KITTTAS COUNTY COMMUNITY DEVELOPMENT SERVICES

December 29, 2020

Subject: Forest Ridge Phase 1 (LPF-20-00005) Final Long Plat – Return of Application and Request for Additional Information

OPEN SPACE COMPLIANCE MAP

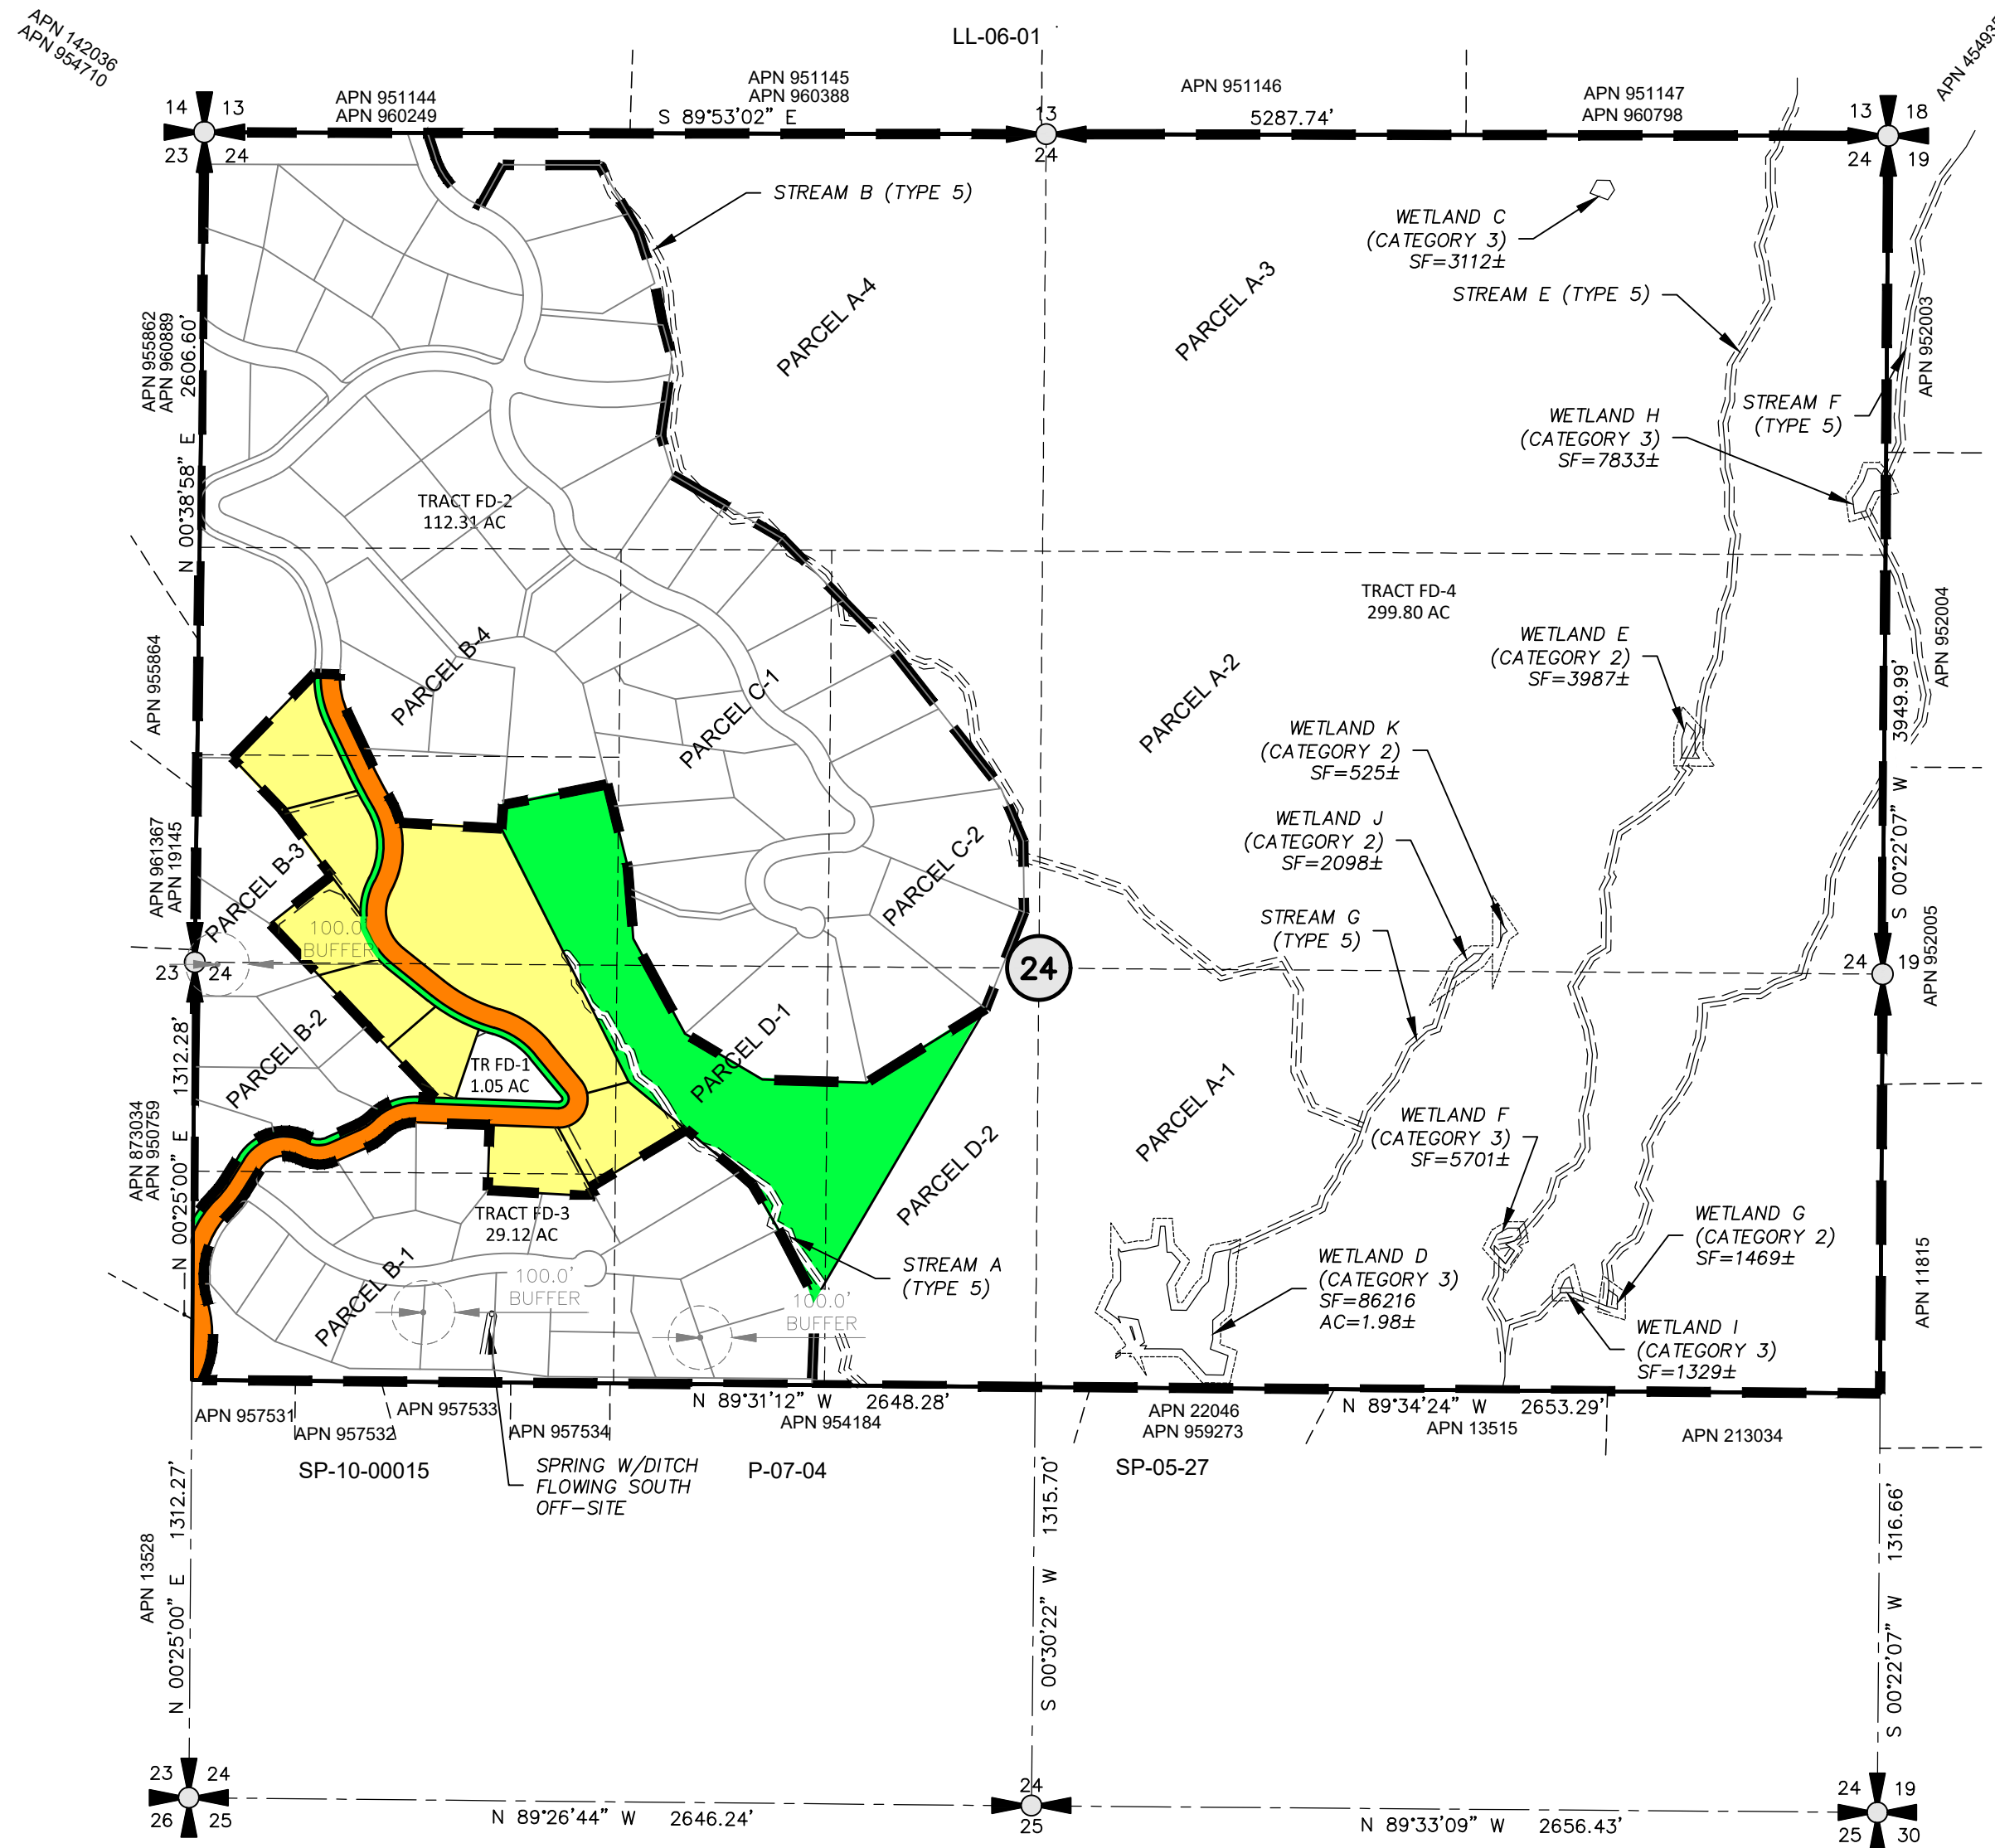
- Final mylars shall include the final plat number LPF-20-00005.
- Resolution 2010-137 Condition 8 states, "Prior to final plat approval, the applicant shall present to the County for review and approval a map demonstrating that at least 40% of the total plat area meets the open space requirements of Chapter 16.09." The condition compliance document provided notes that this map is included in the submittal materials, but staff could not locate this.
